MESA DEL SOL
ARCHITECTURAL CONTROL COMMITTEE
SITE DEVELOPMENT PLAN REVIEW

**RE: Mesa Del Sol Self Storage
5500 Turing Dr. SE
Grading and Drainage Plan
Engineer's Stamp Date: 5/7/2025
Hydrology File: R16DA1004**

**Re: Mesa Del Sol Self Storage
 5500 Turing Dr. SE
 Grading and Drainage Plan
 Engineer's Stamp Date: 01/15/2025
 Hydrology File: R16DA1004**

Here are the responses to the comments provided on March 21, 2025 in regards to an **Updated Grading & Drainage prior to continuing onsite grading and foundation work.**

6
C-3.0

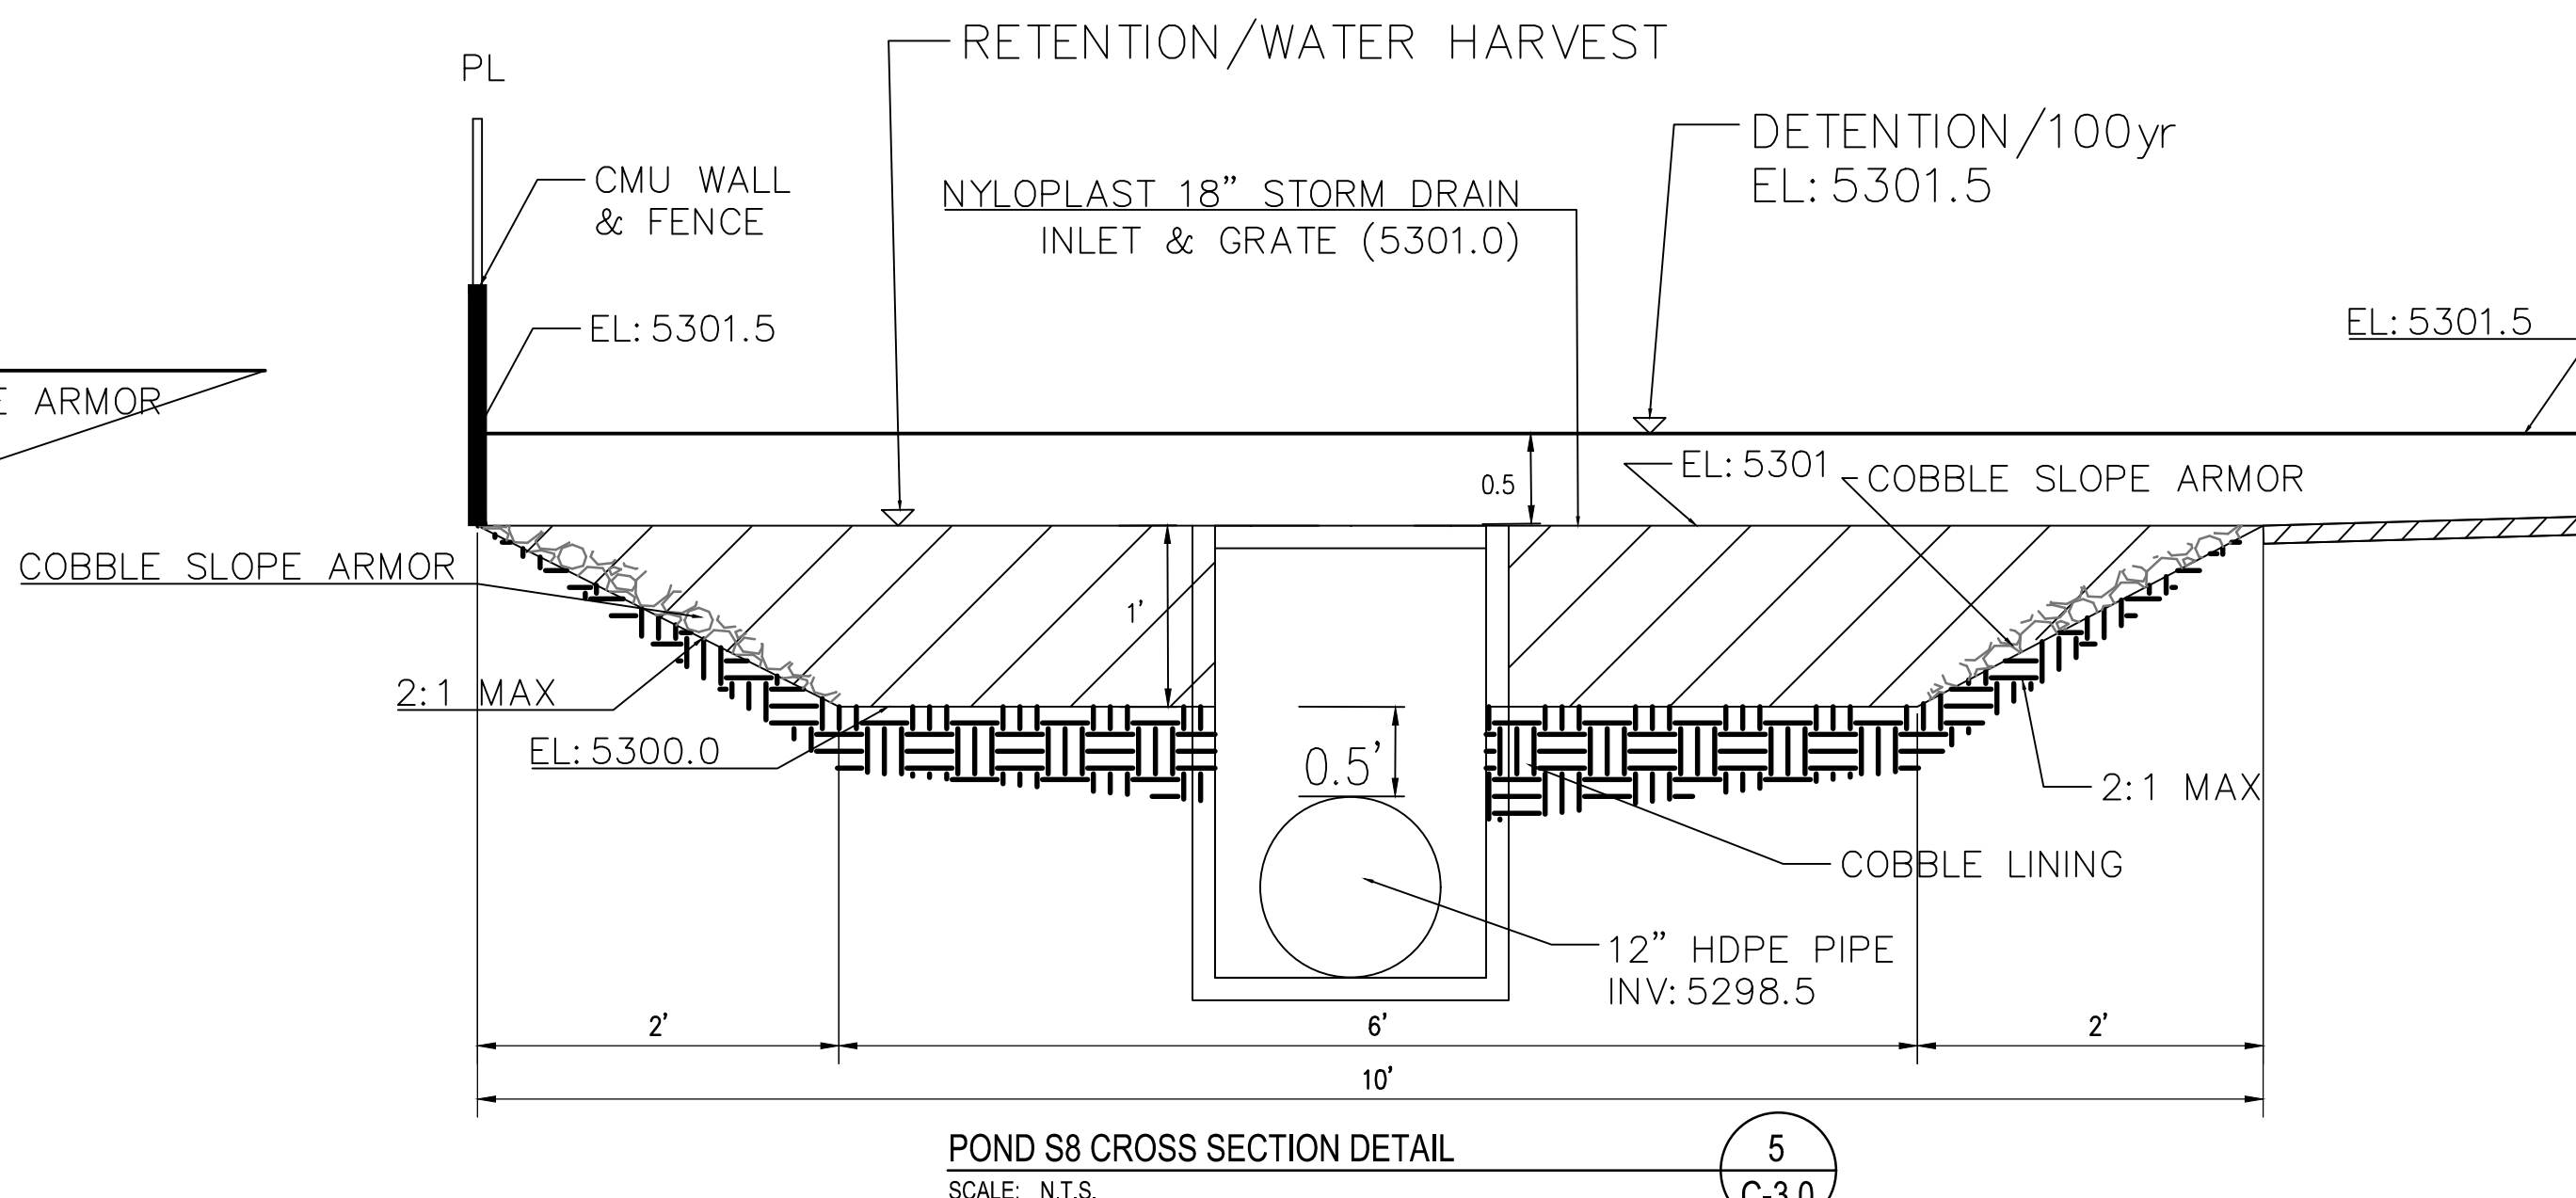
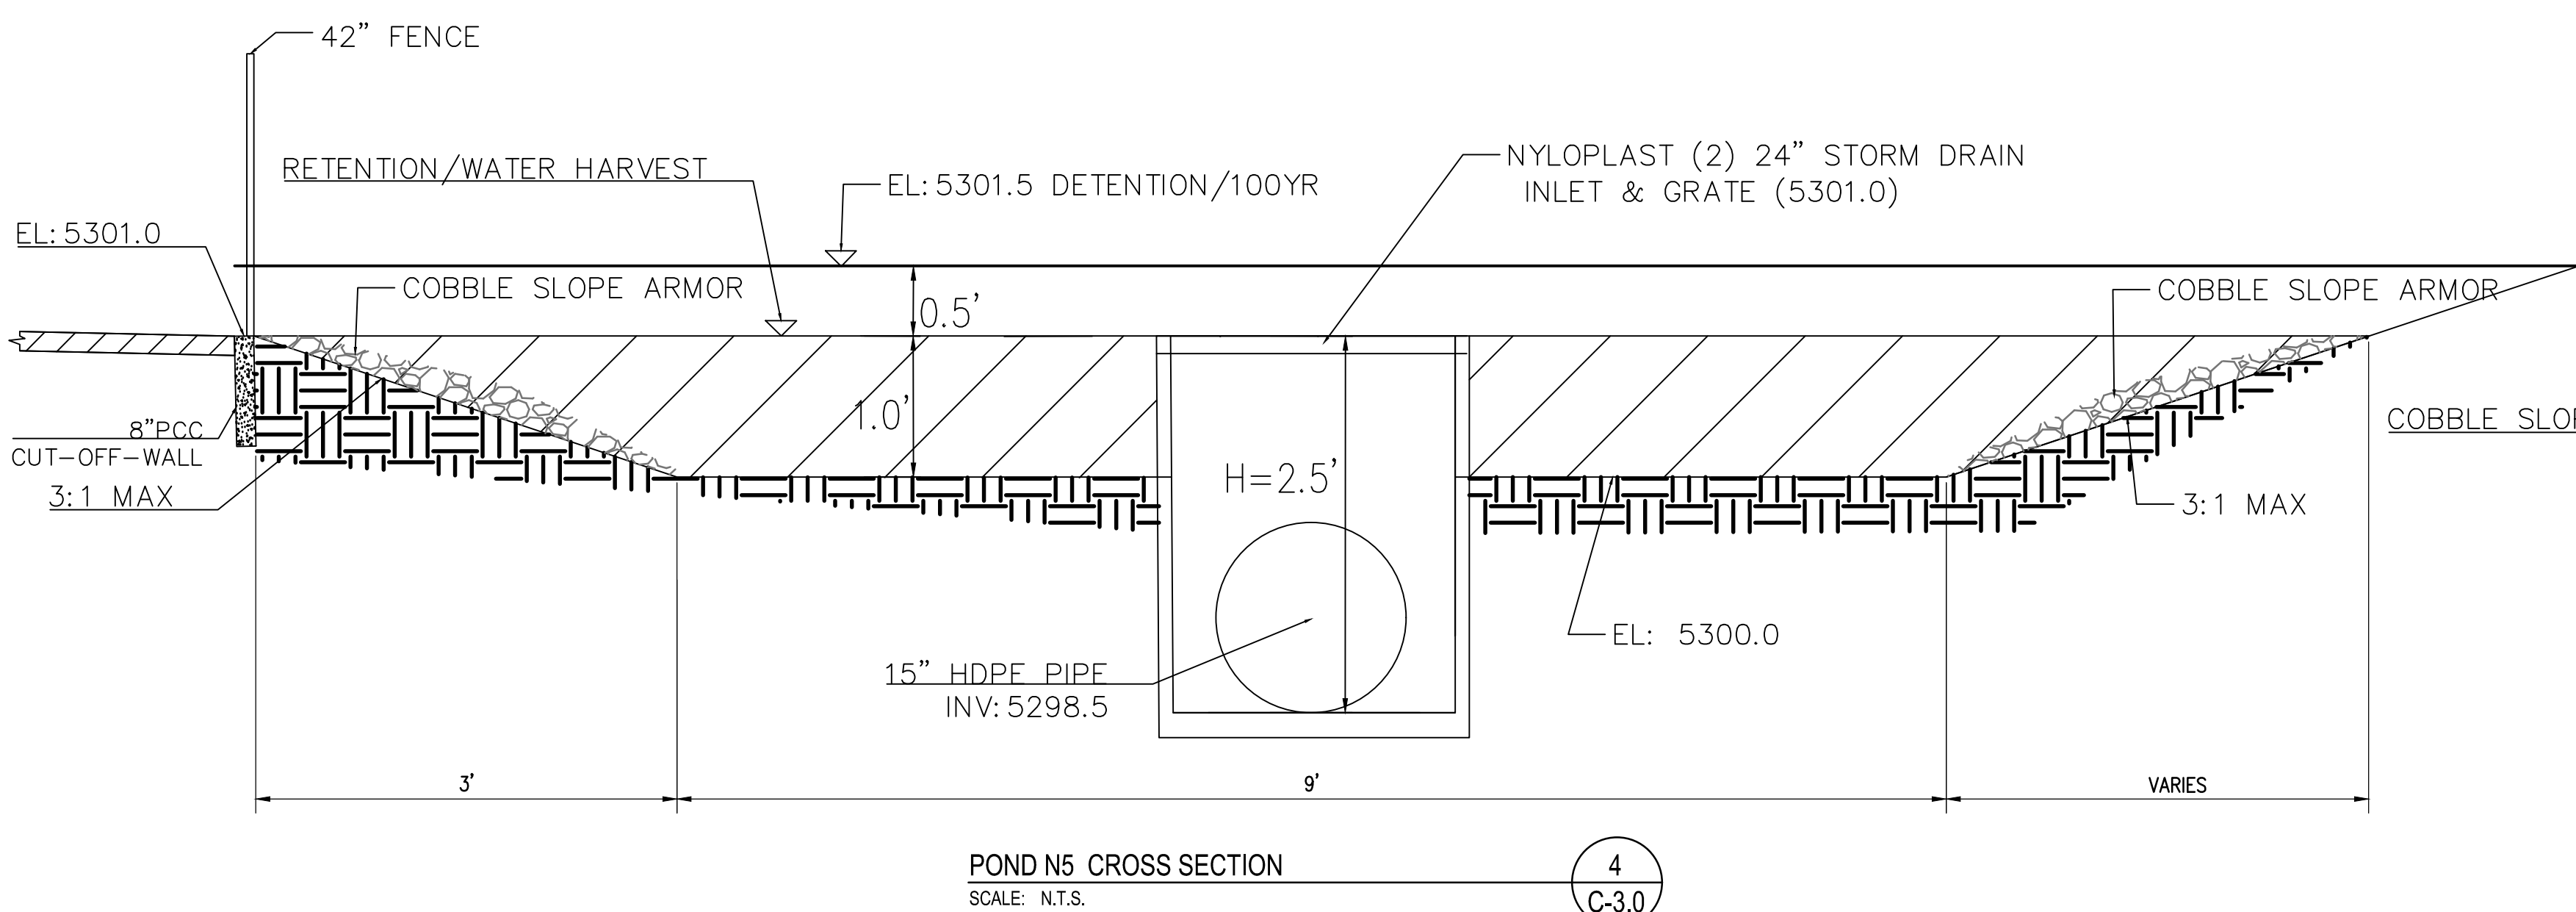
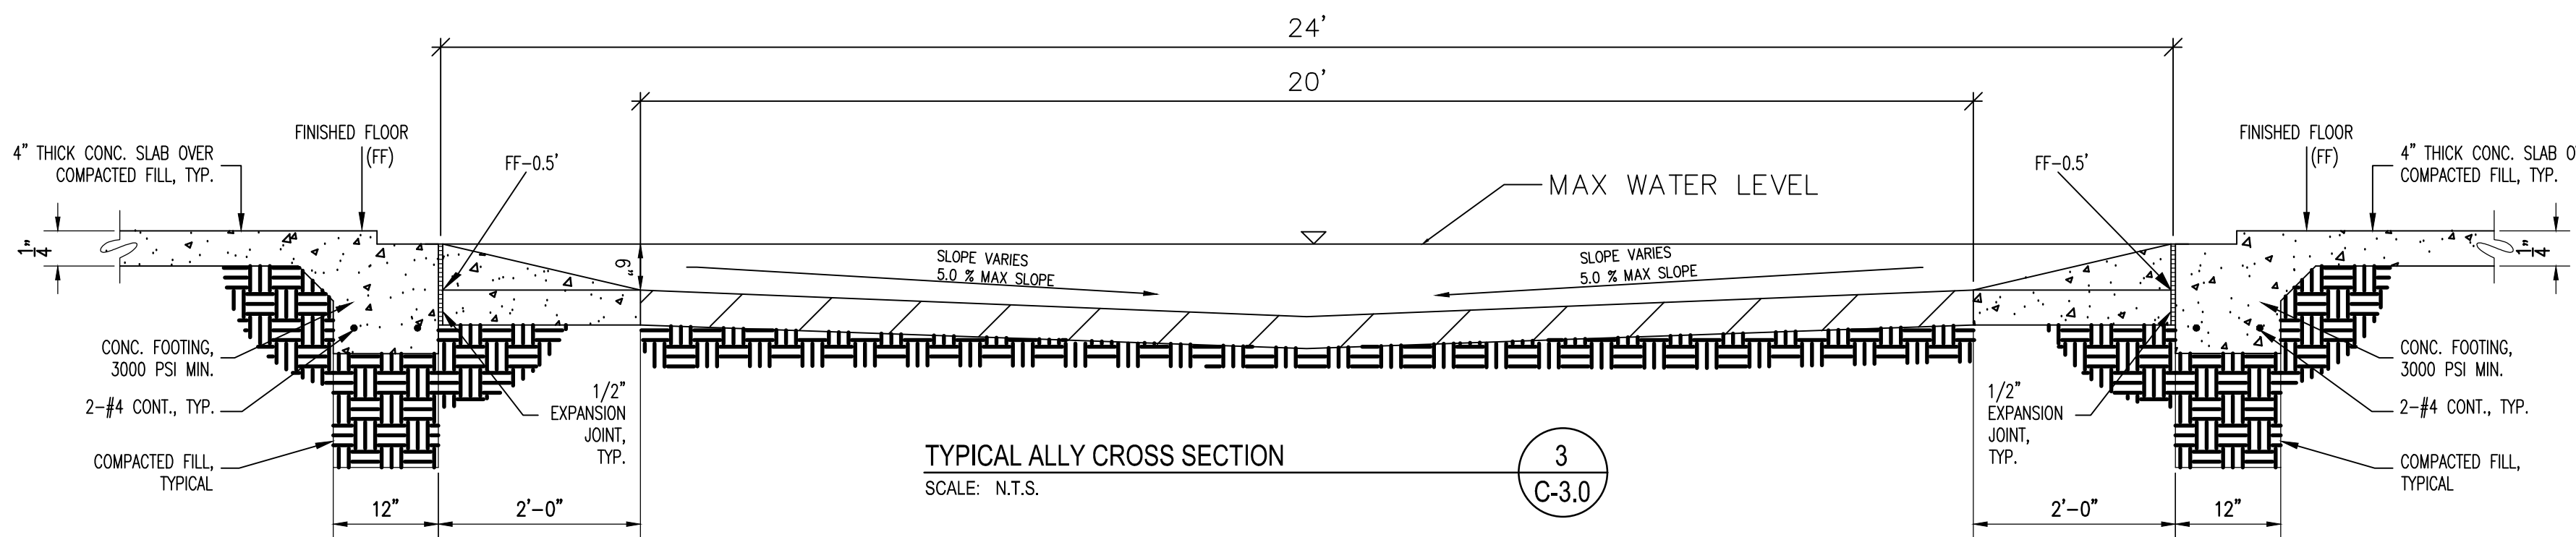
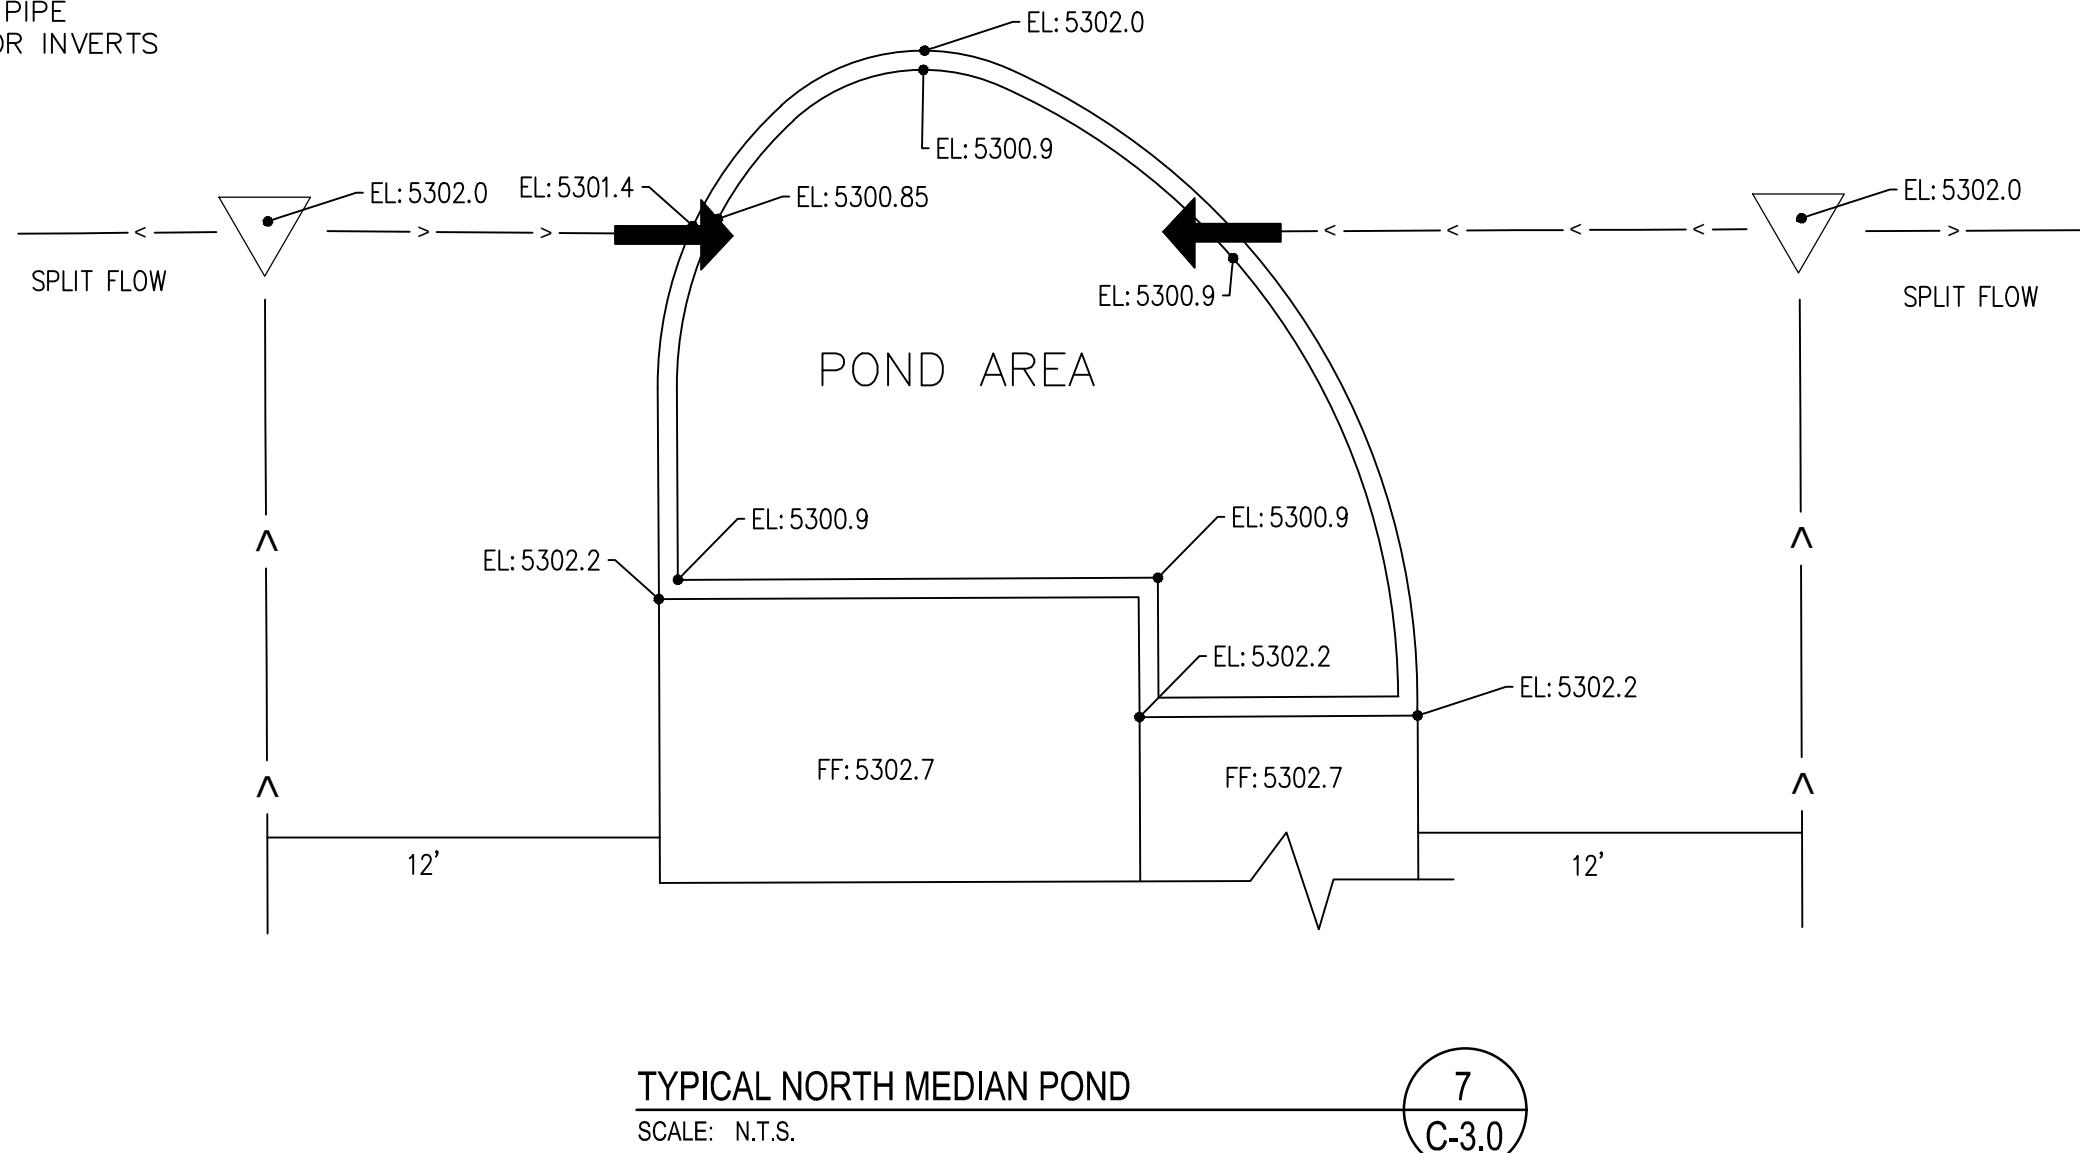
6. Any and all proposals should be presented and demonstrated appropriately on an Updated Grading & Drainage Plan.
Concur. See revised Grading Plan and Details.
